Application No: A/130/21/PL
Site Address: 16 Pine Trees Close Angmering BN16 4LT
Description of works: Demolition of existing garage, conversion of extension (approved under A/66/21/HH) to 1 No. 2 bed dwelling, provision of 4 parking spaces and cycle/refuse storage. This application is within CIL Zone 2 and is CIL liable as new dwelling.

Thank you for your internet representation made on 24th August 2021 which has been recorded as an objection with the comments as follows:

O5 PROPOSED ELEVATIONS
SCALE 1:50 @ A1

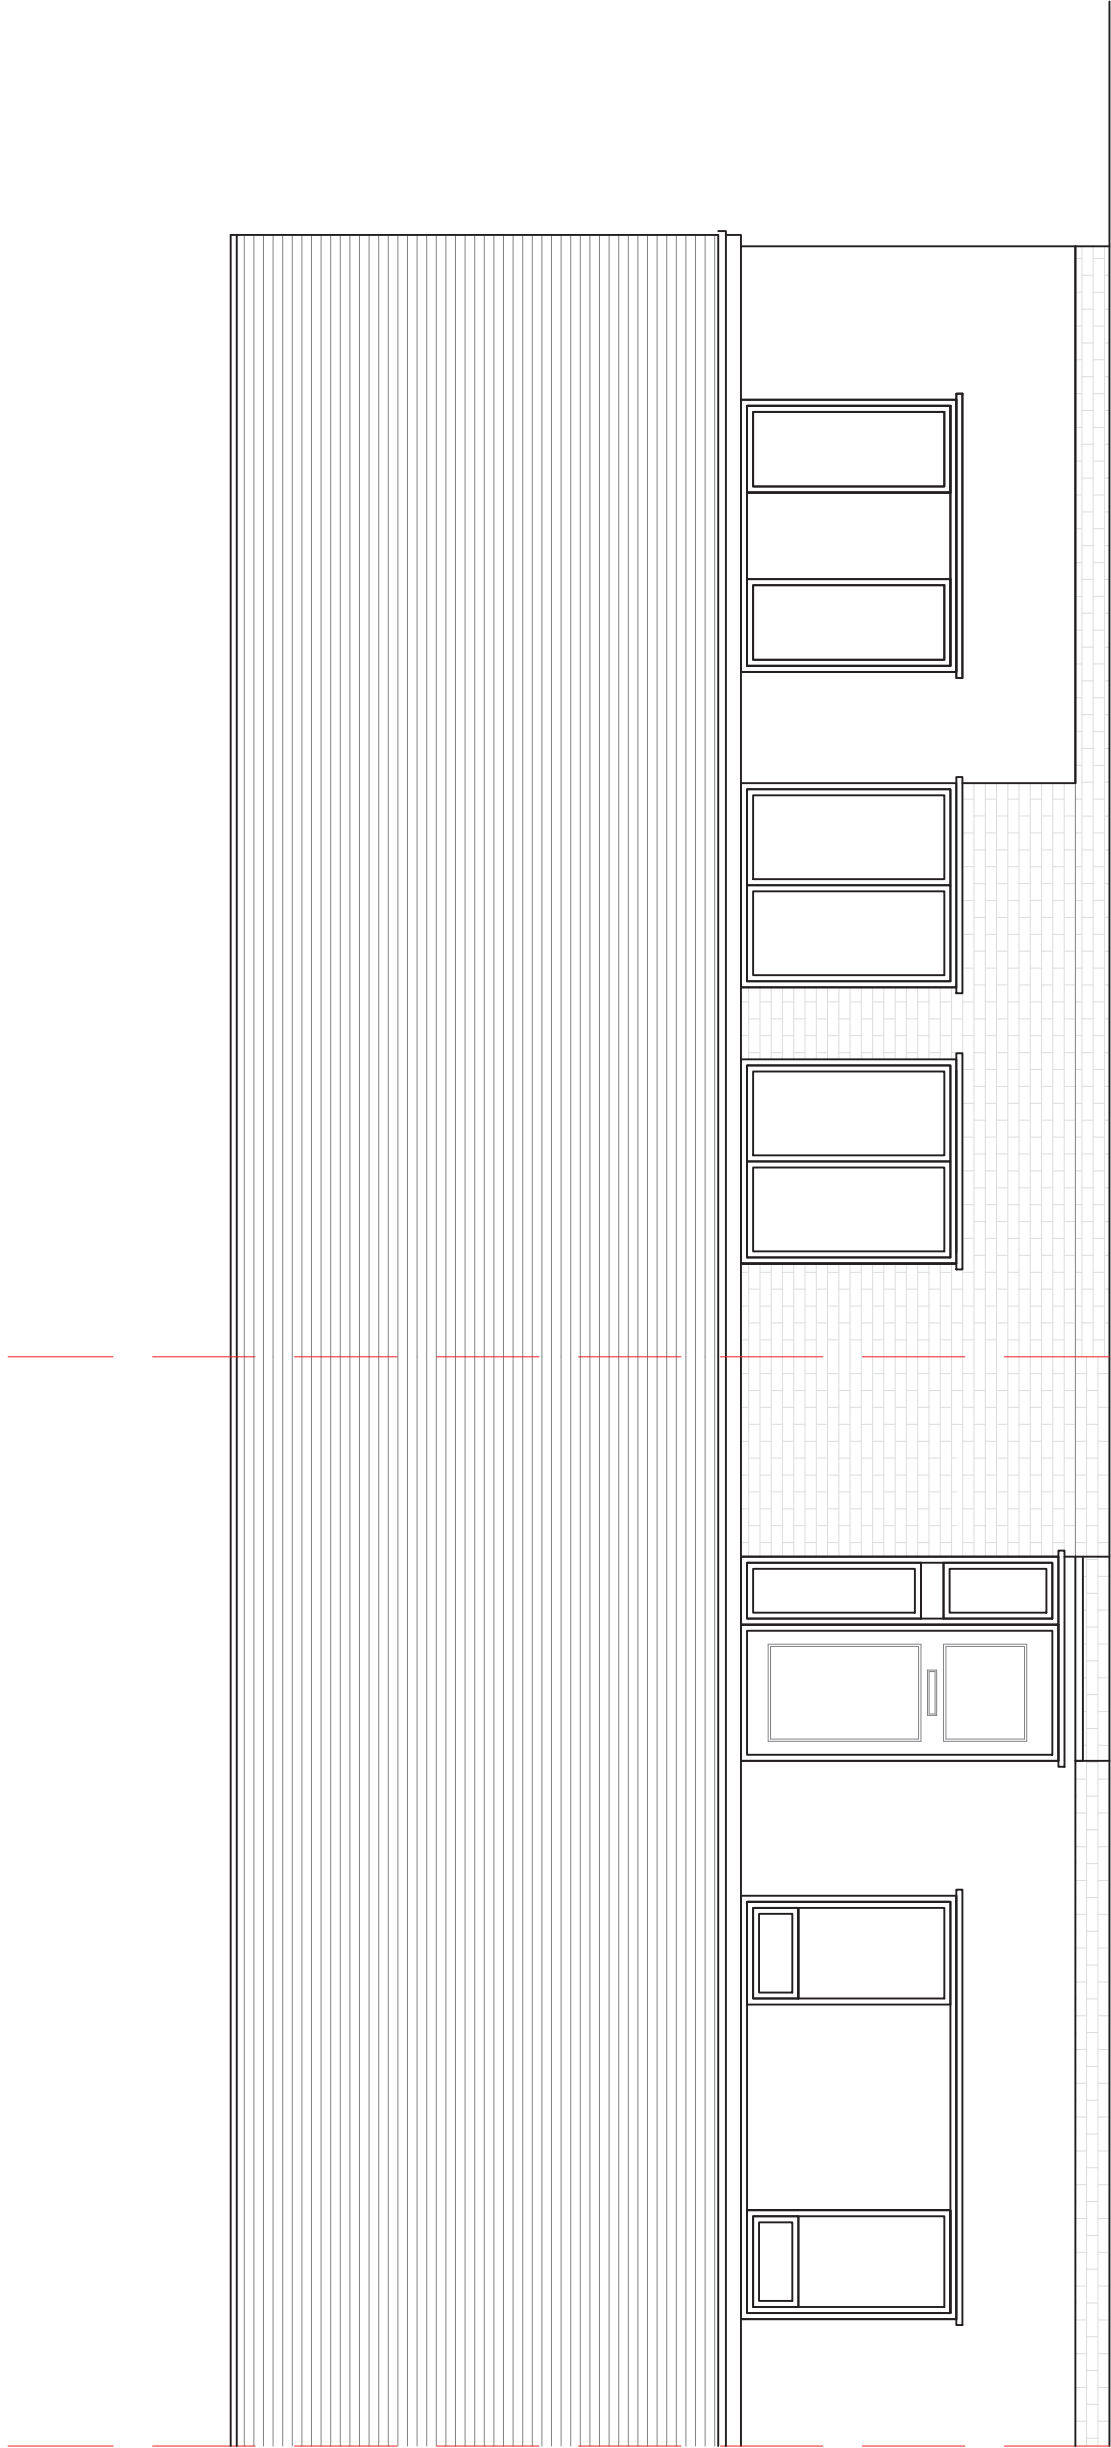
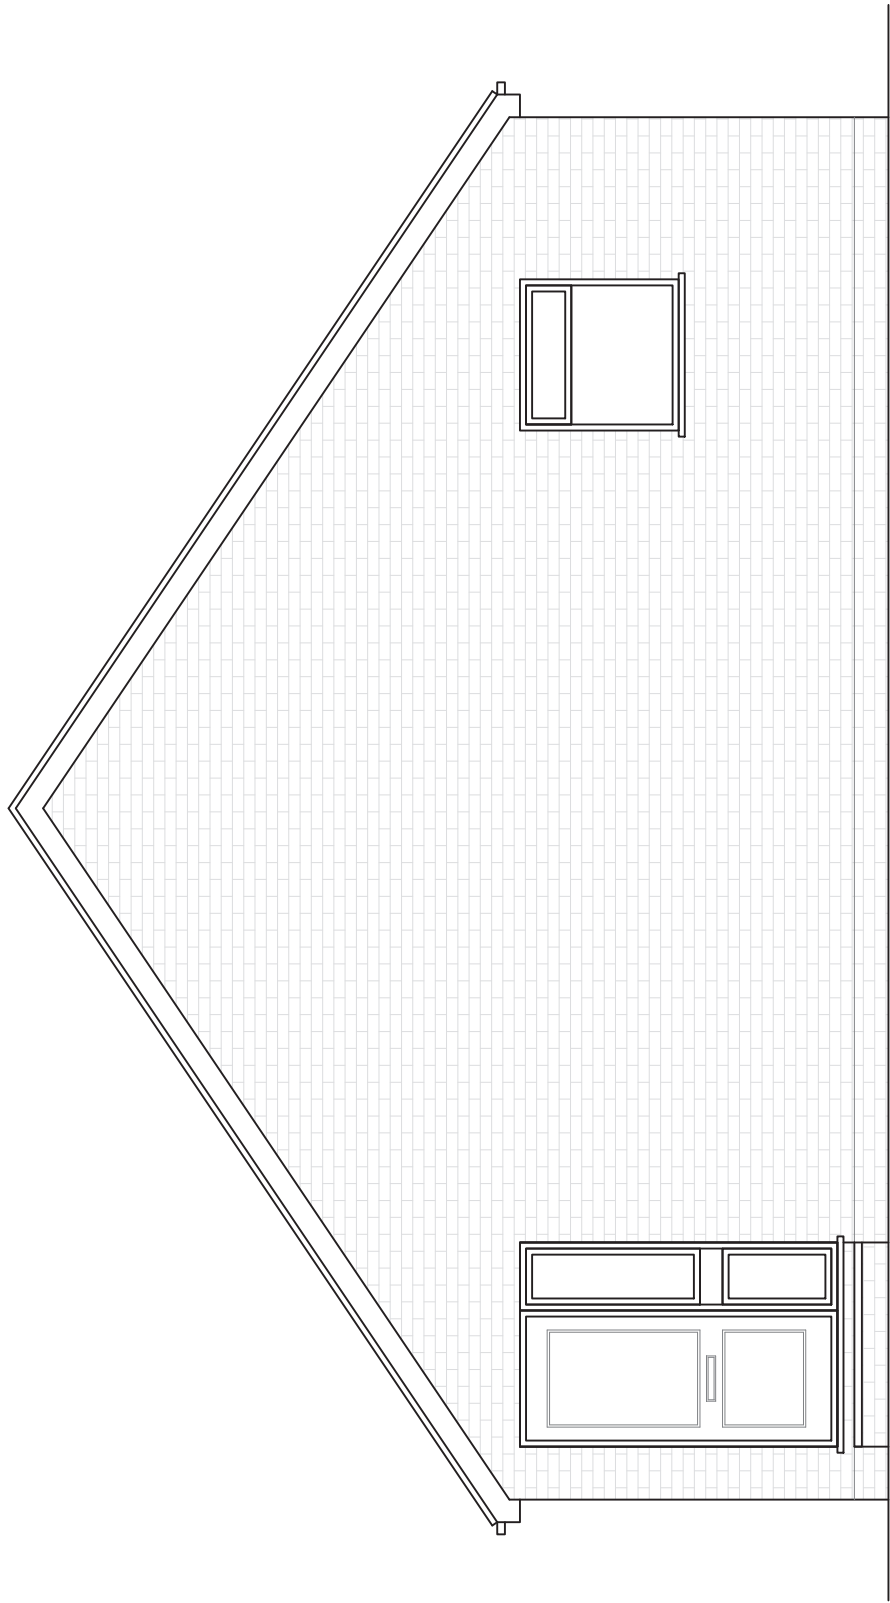
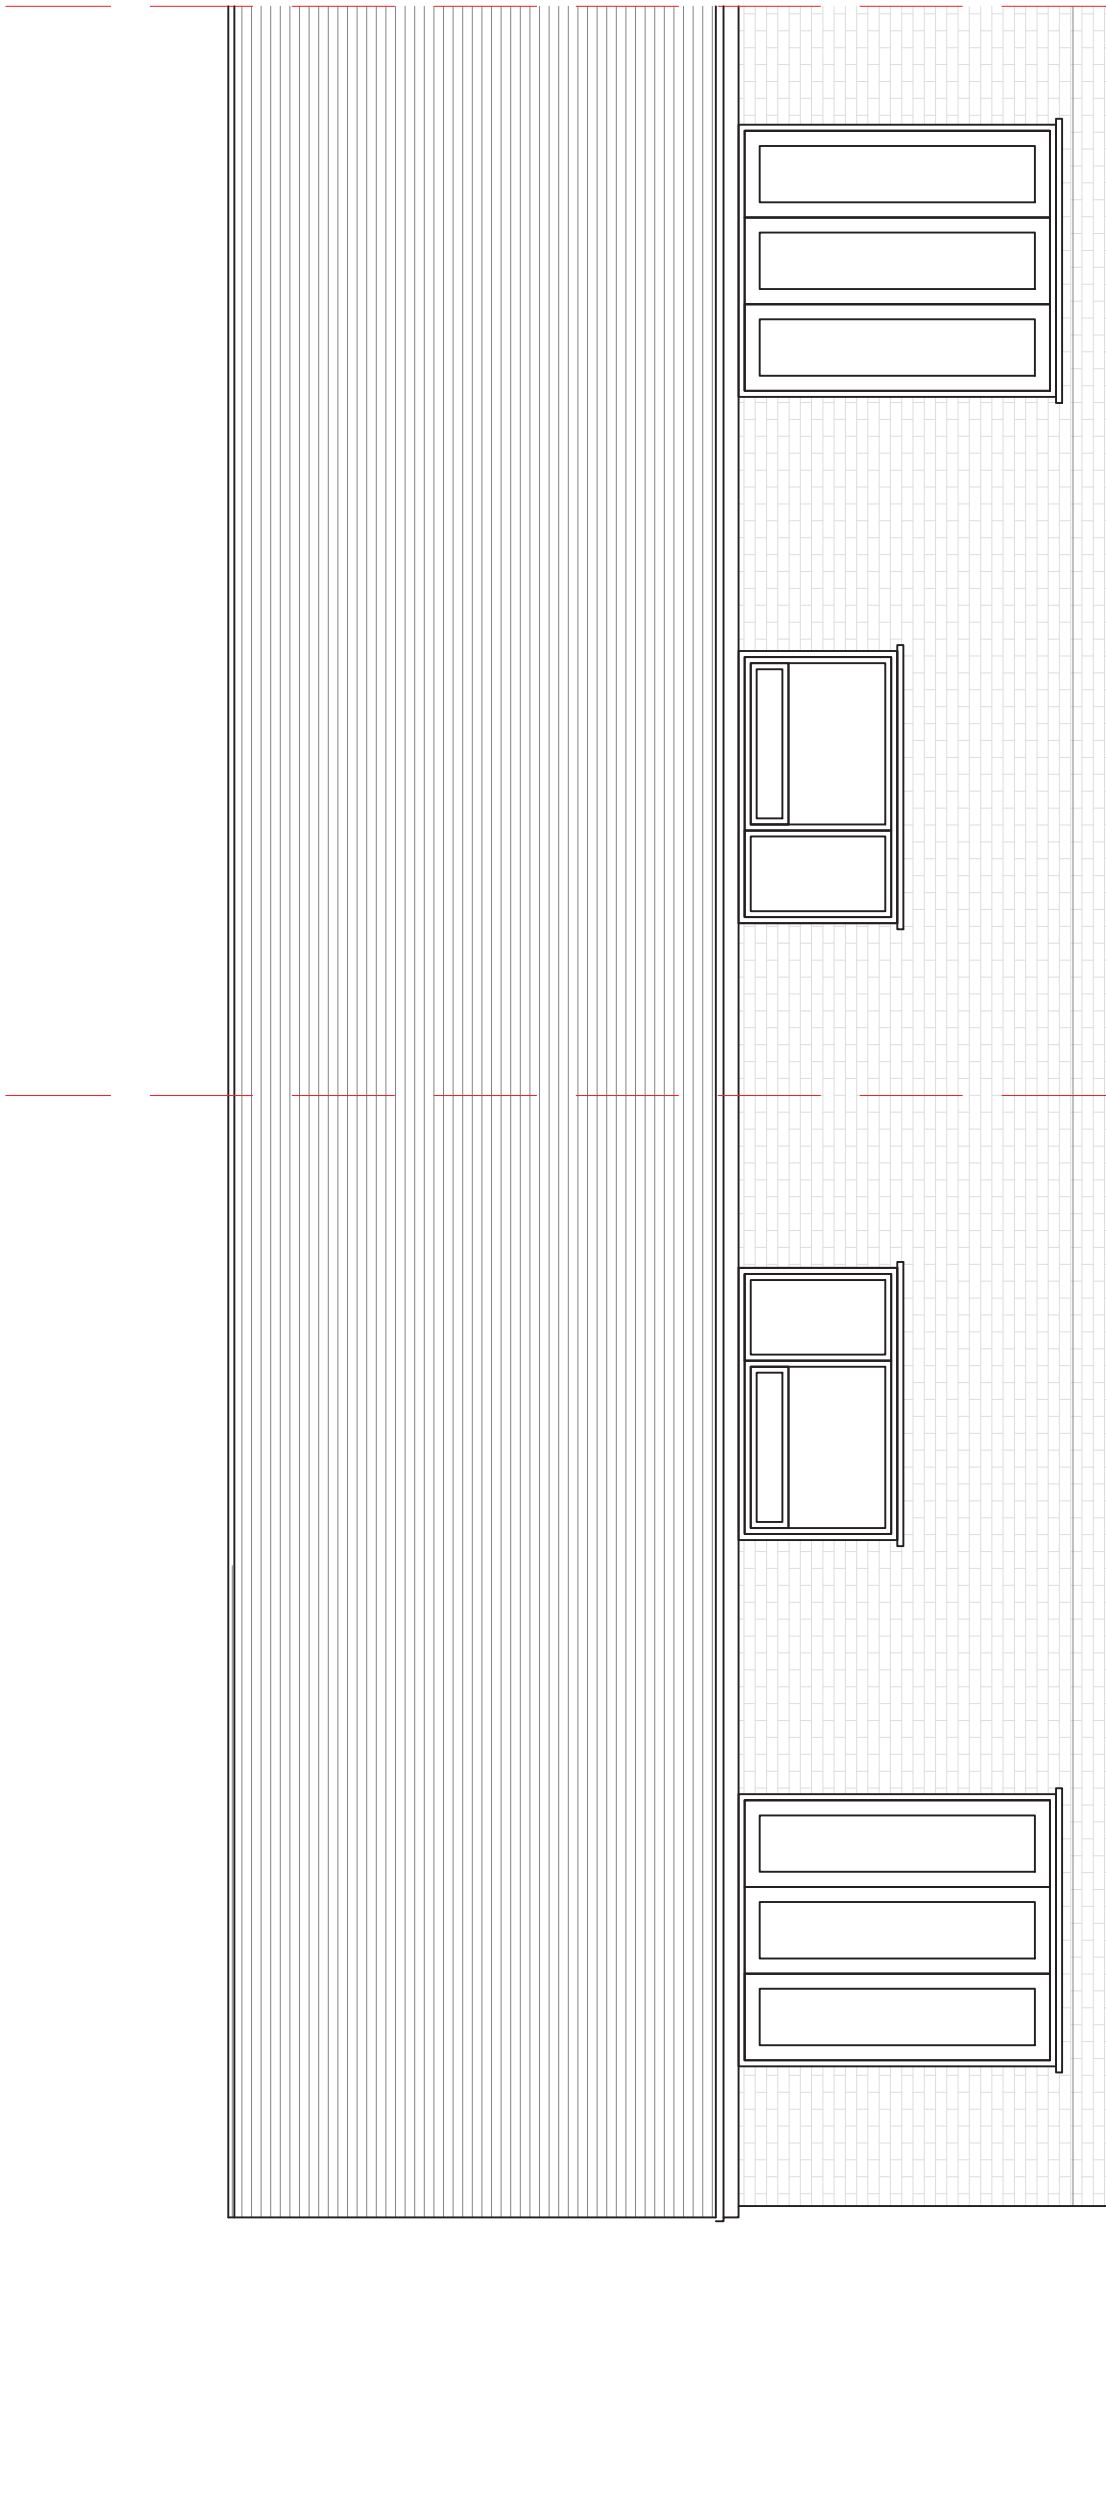
Additionally, creating a terrace of three dwellings would be completely out of character with the rest of the housing in this area.

BLOCK PLAN (SHOWING PROPOSED)
Scale 1:200

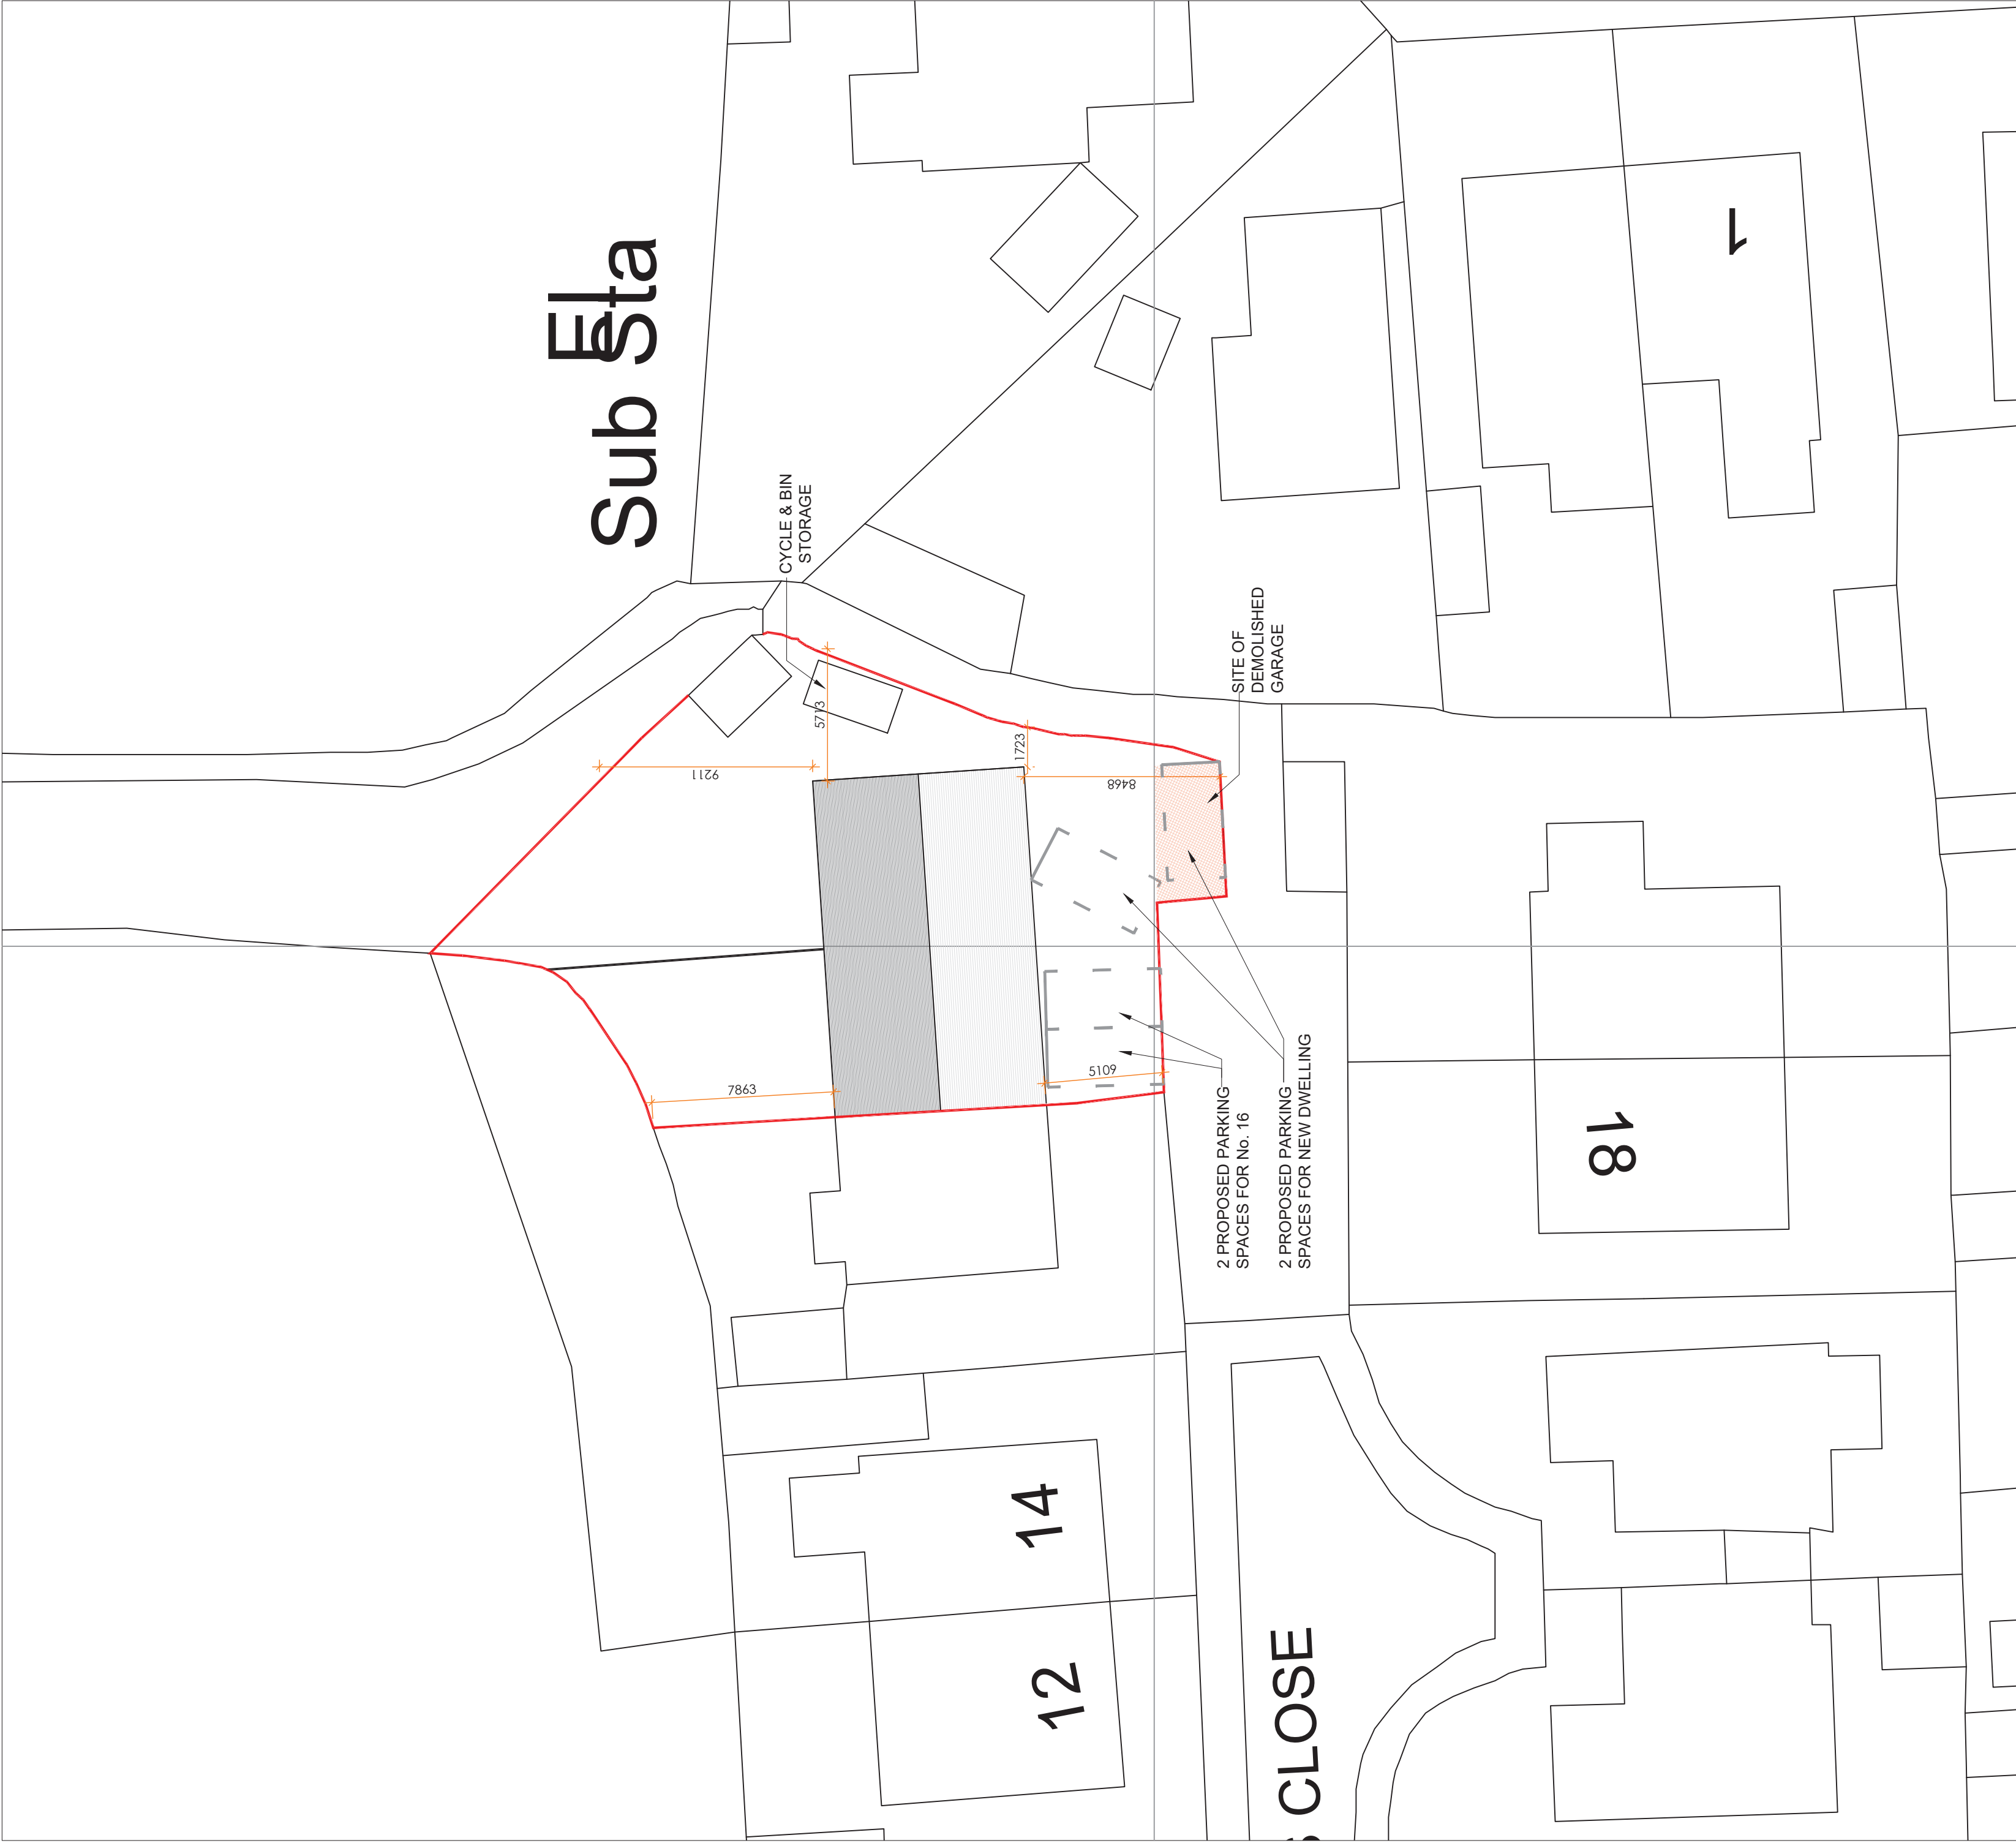
Whilst we had no objection to the original proposed extension, the conversion of this into an additional dwelling, along with the provision of four parking spaces, all of which would be directly in front of our living room window, is another matter entirely.

The additional vehicle traffic, again all passing our window, would be unacceptable to us and our outlook would be adversely impacted by the number of parked cars.

Also it should be bourn in mind that the narrow footpath which separates our drive from the proposed access for the four parking spaces will become a point of pedestrian access to the eighty-odd houses currently being built on the land off Dappers Lane, creating a pedestrian hazard.
